Application Ref:	3/2026/0480			 Ribble Valley Borough Council www.ribblevalley.gov.uk
Date Inspected:	21/08/2026	Site Notice:	07/08/2026	
Officer:	AR			
DELEGATED ITEM FILE REPORT:				APPROVAL

Development Description:	Proposed demolition of existing conservatory, erection of two-storey rear extension, new entrance porch and installation of rooflights.
Site Address/Location:	16 Warren Fold Hurst Green BB7 9QS

PROPOSED SITE PLAN

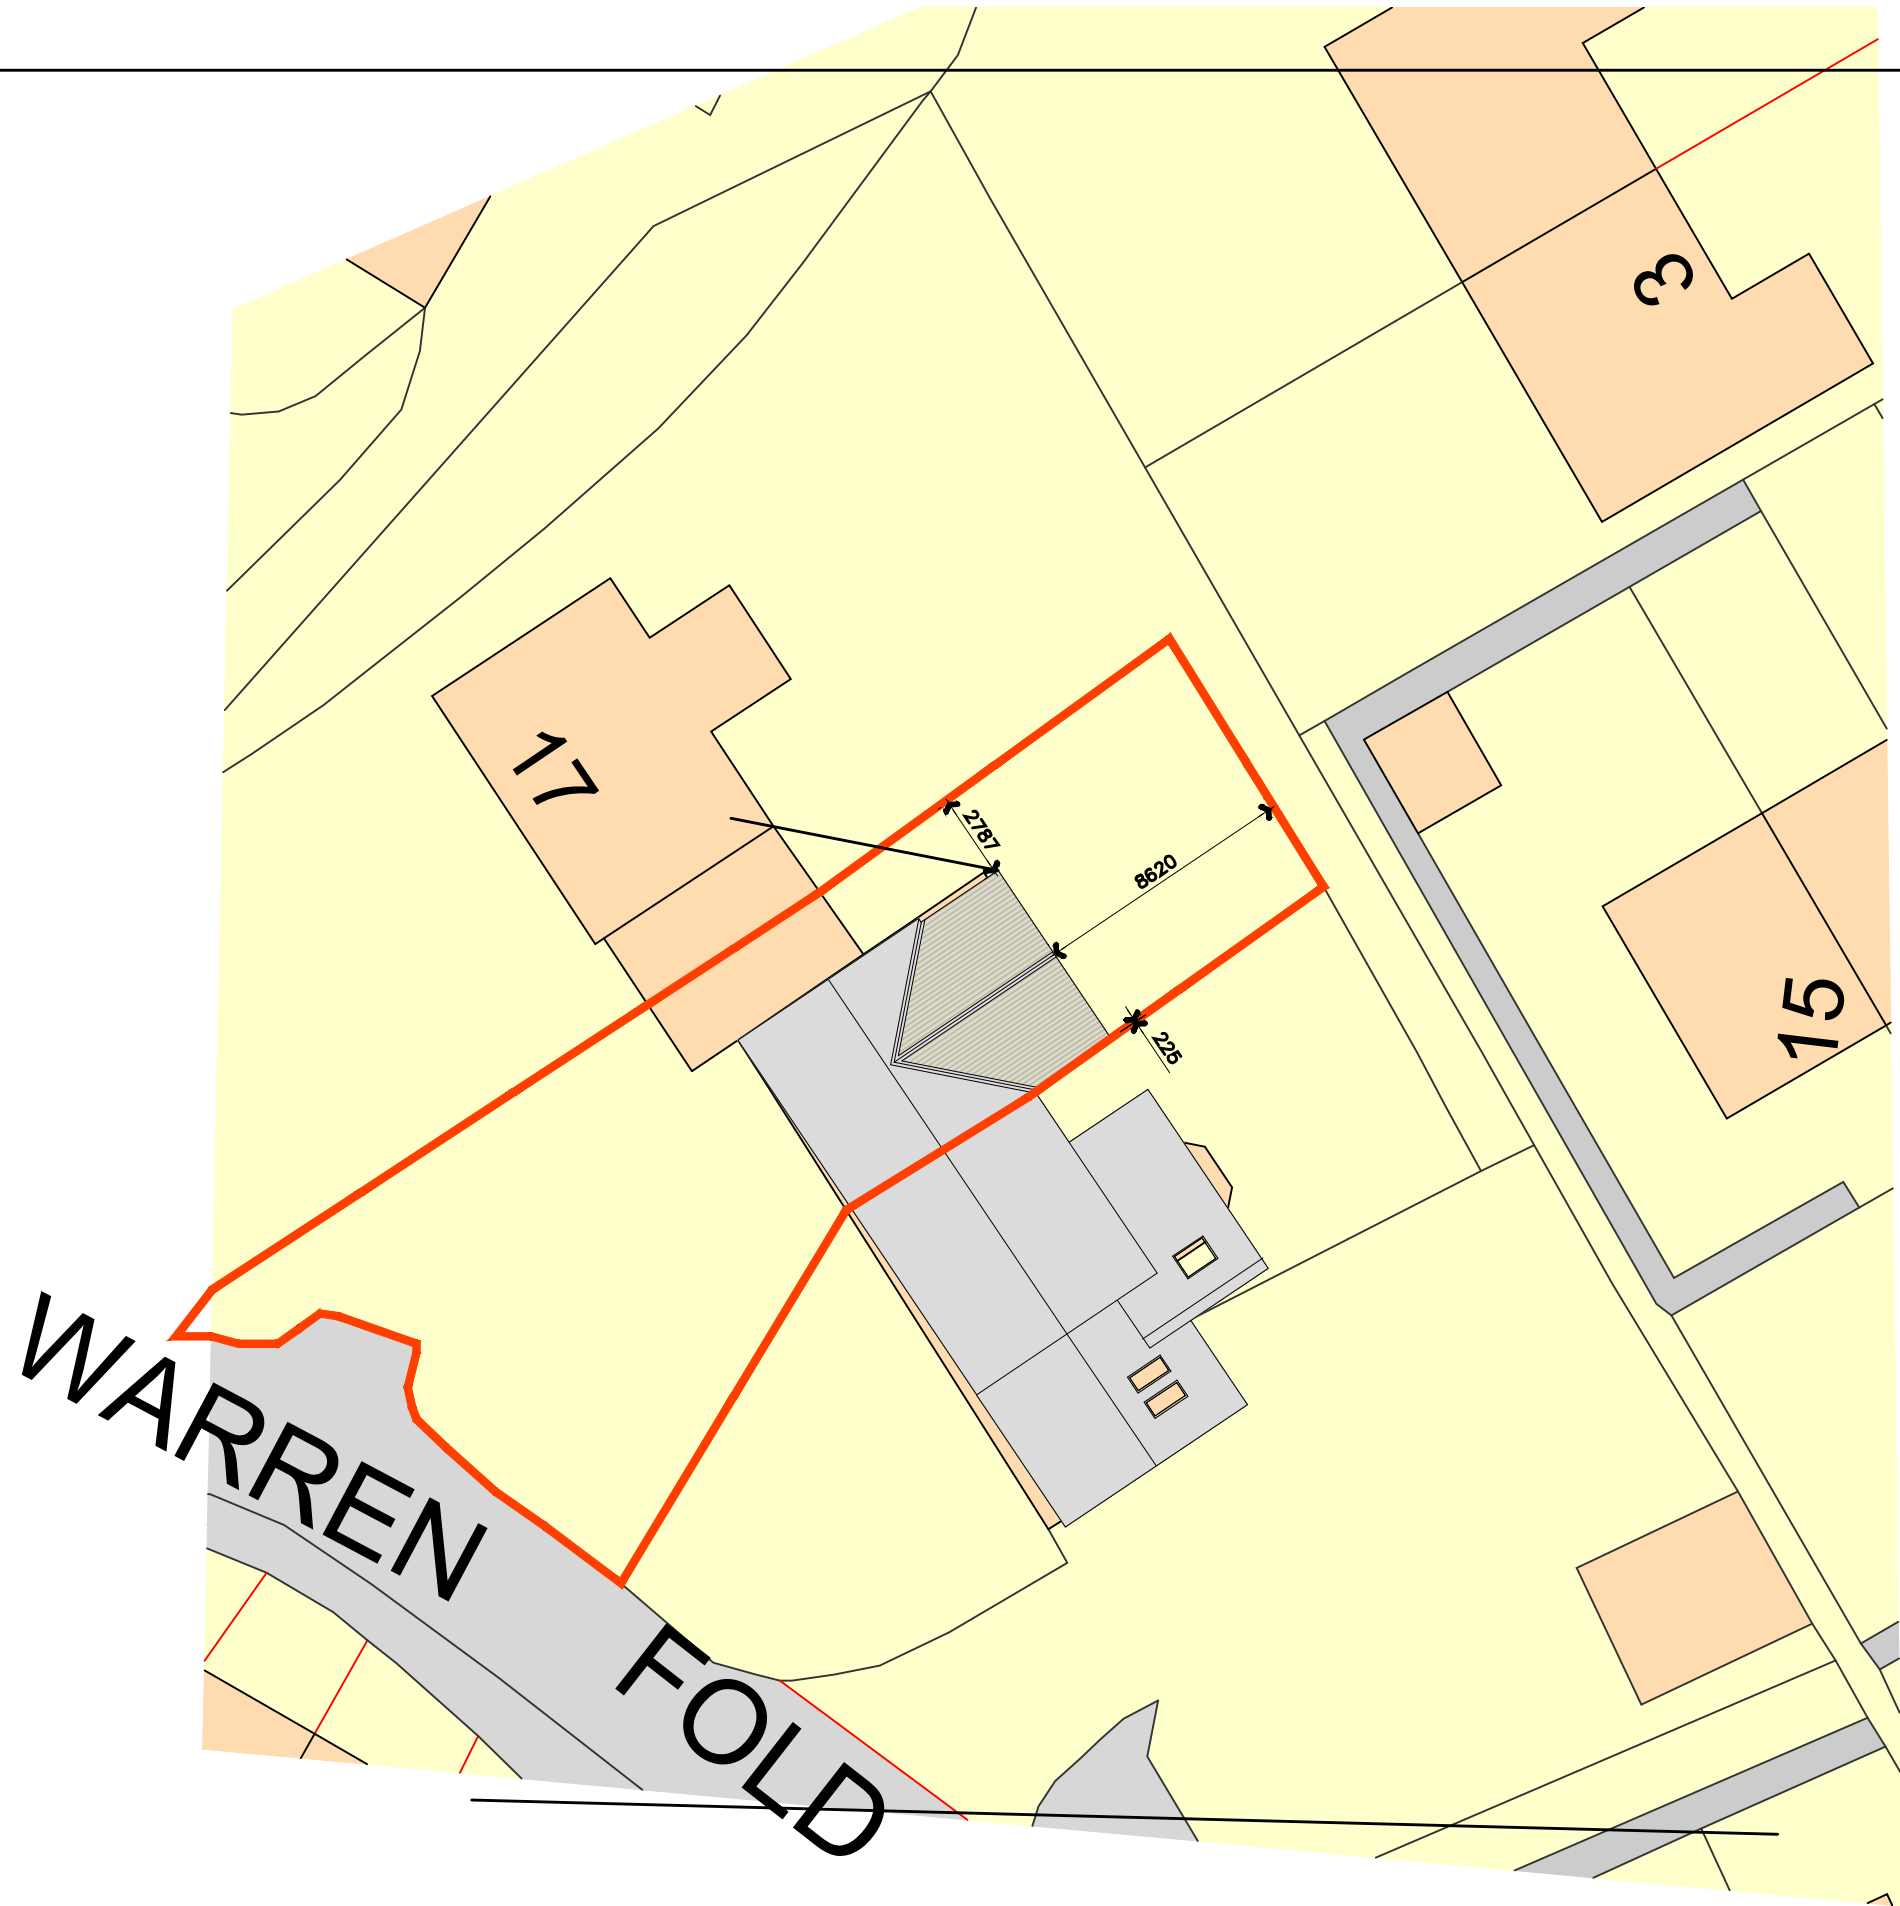
While the proposed two-storey rear extension would be set back from the south-east and north-west curtilage boundaries, thereby mitigating any potential overbearing impact on neighbouring properties, its height of 6.735m and width of 6.693m present some potential for overshadowing the windows of No’s. 15 and 17 Warren Fold. No. 17 Warren Fold is partially protected from this impact by the presence of No. 16’s garage, which is located between the dwellinghouse and the proposed two-storey extension. In contrast, No. 15 Warren Fold would be separated from the proposed development by only 0.225m. However, whilst the proposal would result in some impact on the ground floor shower room and a slight impact on a first floor bathroom at No. 15 this would not result in any loss of light to habitable rooms and, as such, this does not raise any undue concerns. Additionally, the proposed porch would extend 1.28m beyond the front elevation but would not be positioned in close proximity to any neighbouring habitable room windows. Overall, the proposed development is not considered to result in any significant loss of outlook or daylight to any neighbouring habitable room windows, and therefore has an acceptable relationship with this neighbouring residential receptor.

Nonetheless, due to the proposal increasing the number of bedrooms from 3 to 4 and therefore increasing the required number of parking spaces, the planning officer requested a parking plan demonstrating that the site has capacity for 3 standard parking spaces; this was submitted on 28/08/2026. Accordingly, with regard to highways and parking, there are no objections to the proposal, and it complies with Policies DMG1 and DMG3 of the Ribble Valley Core Strategy.

PROPOSED GROUND FLOOR
PLAN

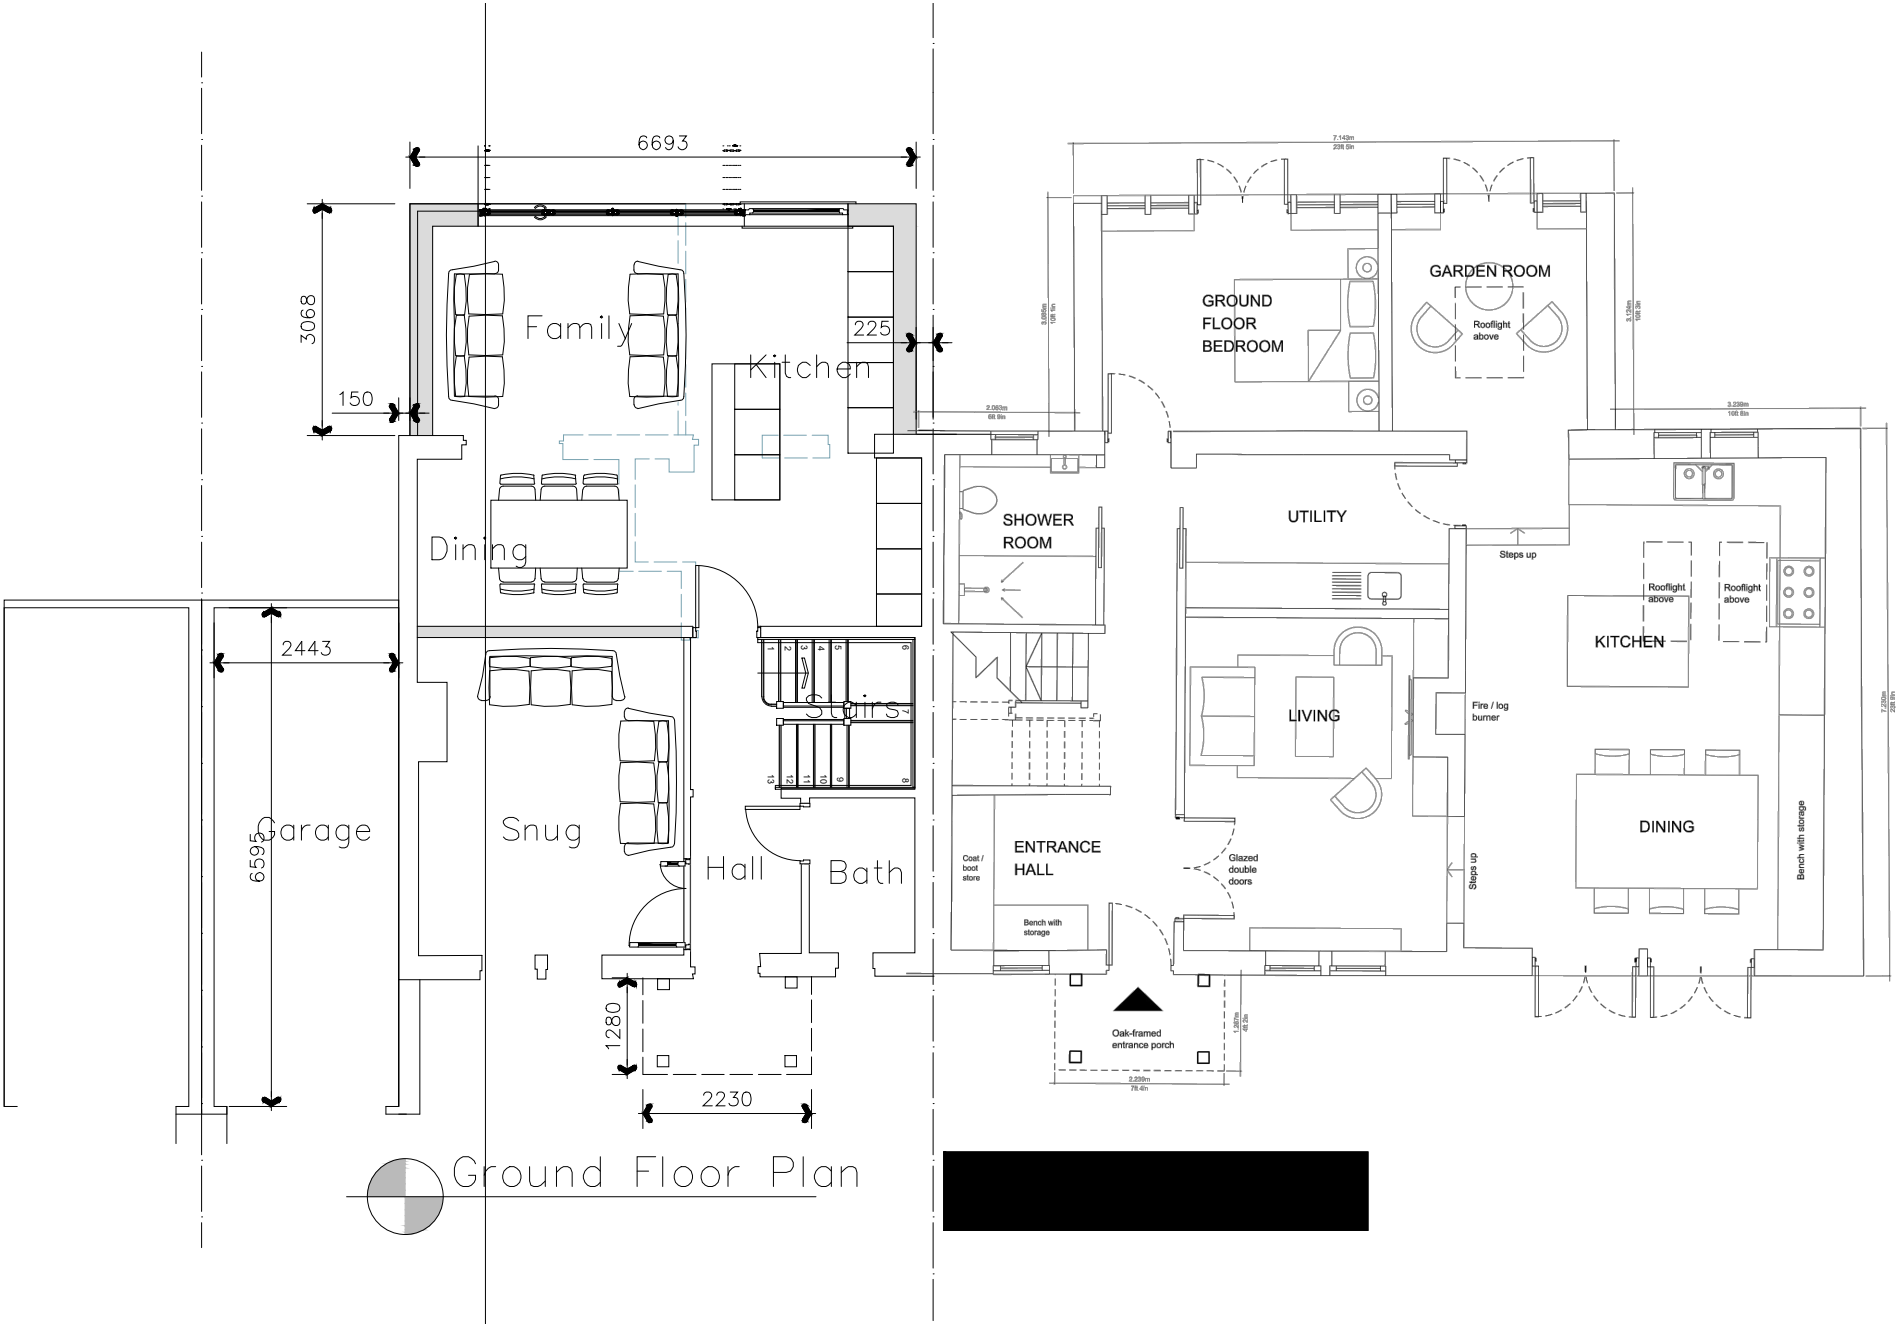
Whilst the proposed front porch would be publicly visible from the highway, the proposal would be sympathetic to, and reflective of, the existing dwellinghouse by virtue of its modest proportions and design, therefore resulting in a wholly subservient addition to the property. Furthermore, the proposed porch would be of a similar appearance to the front porch at No.15 Warren Fold, being constructed from an oak frame with open elevations and a slated pitch roof. As such, the proposed addition is considered an acceptable form of design, with its overall scale, massing and materiality not significantly impacting upon the street scene or the visual amenities of the surrounding area. Furthermore, the application dwelling also benefits from a relatively large front garden area, with the property itself being set back from the highway of Warren Fold. In this respect, the proposed porch extension would not appear an over-dominant or anomalous addition to the application property or the wider street scene.

PROPOSED ELEVATIONS  
(Sheet 1 of 2)

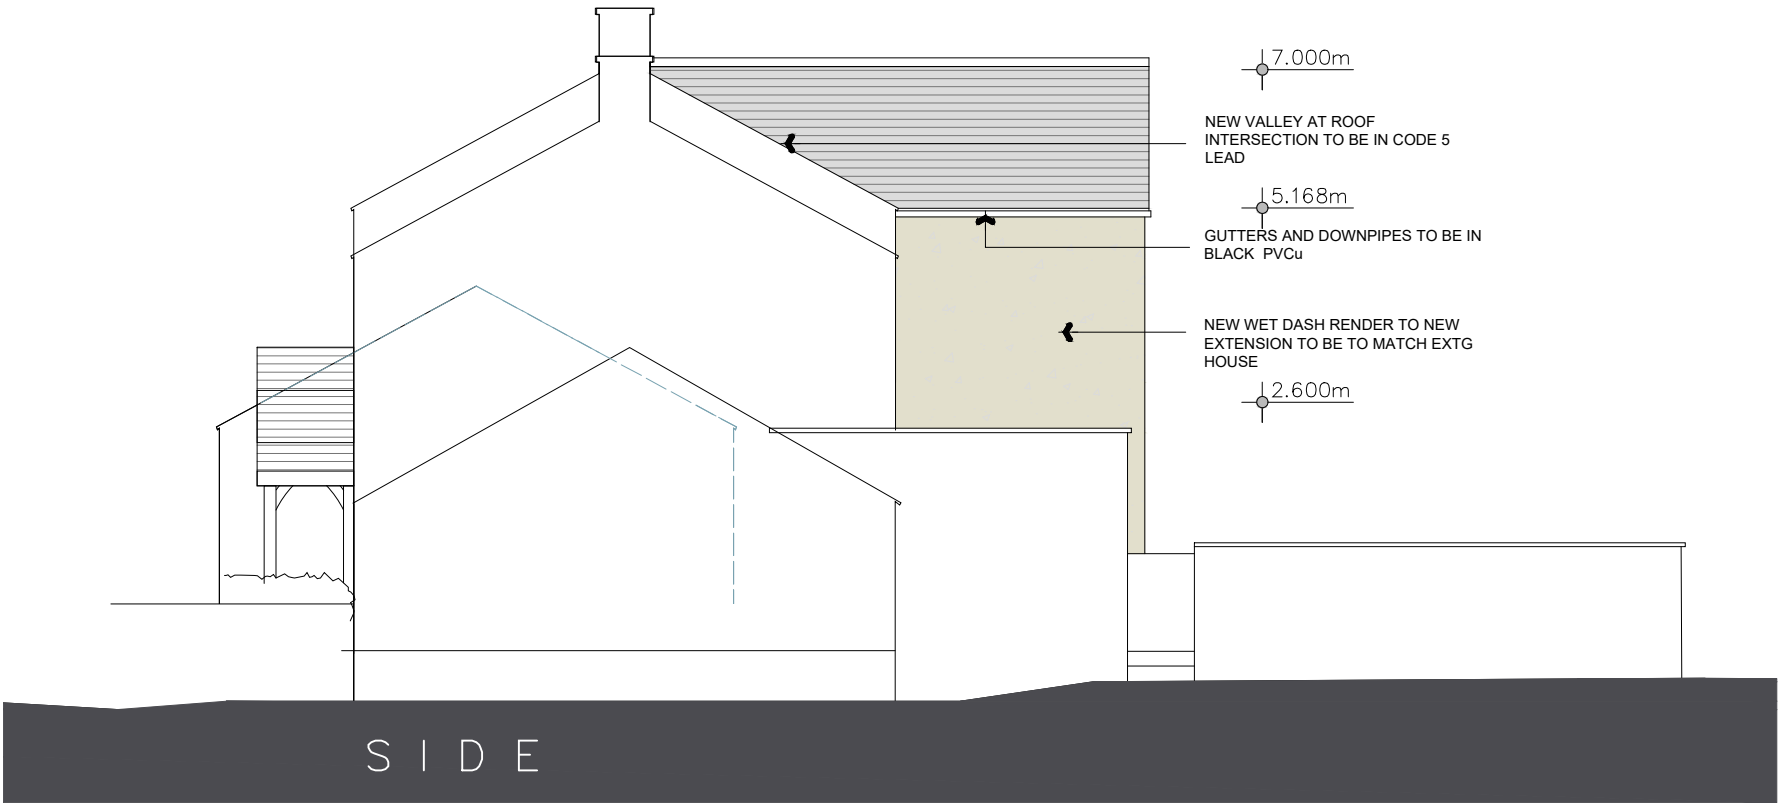
The planning officer requested an amendment prior to the determination of this application to ensure the proposal's acceptability. The amendment sought was to lower the two-storey rear extension's ridgeline to make the proposed extension appear more subservient to the dwellinghouse; these amended plans were received on 28/08/2026.

The proposed two-storey extension would project 3.068m from the rear elevation of the application dwelling and would have an eaves height of 4.685m and a ridge height of 6.735m. The side elevations of the proposed extension would be set in from the side elevations of the dwellinghouse, and an amendment has been secured to reduce the ridgeline to 6.735m from 7m. Therefore, the proposed two-storey extension would take a subservient position in relation to the primary dwelling house and would not read as an overtly incongruous or over-dominant addition to the immediate or wider locality.
